Subject: Jemalong Solar Farm Project (SSD8803)

Council is in receipt of the Environmental Impact Statement for the Jemalong Solar Station 50MW Photovoltaic Plant.

Council raises the following comments for consideration in the assessment of the application.

Figure 2.1 Development extents and 1978 Guideline Levees (purple) and FMP approved levee (red)

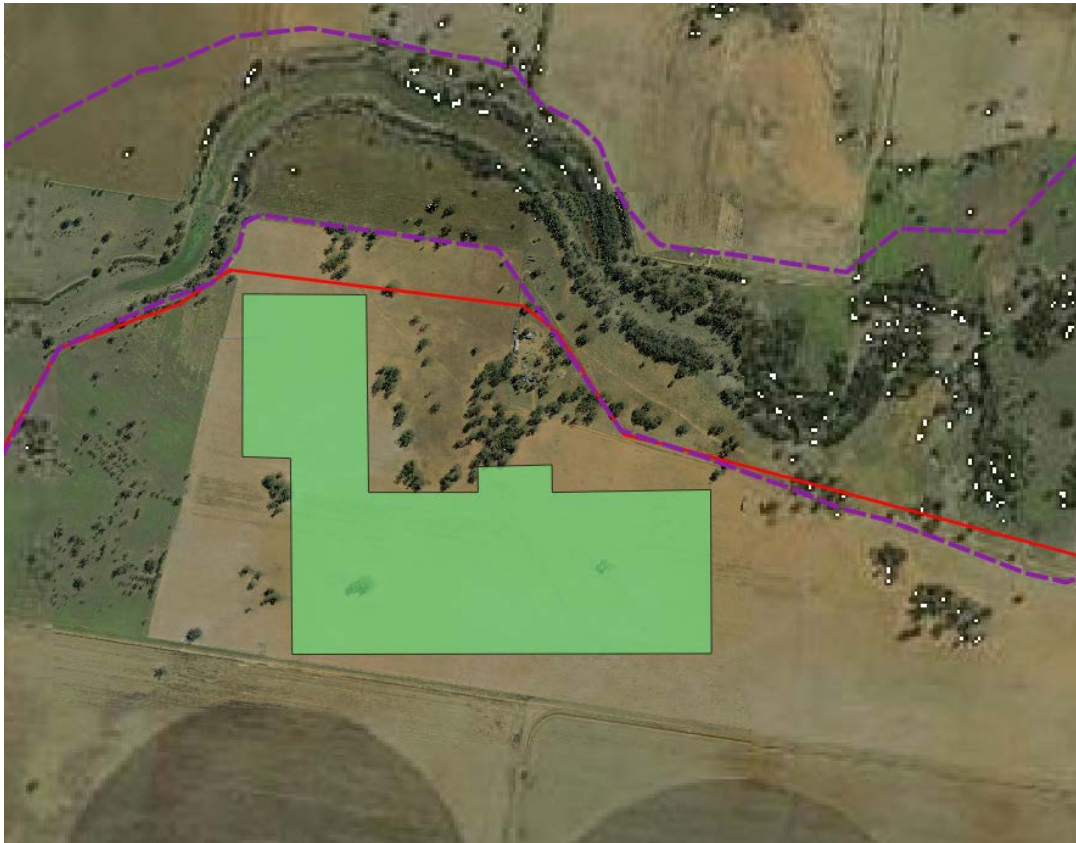
The proposed development is located on flood-labile land. Any structures located within the floodway should be designed to be capable of withstanding flood waters and debris which may impact on the structures.
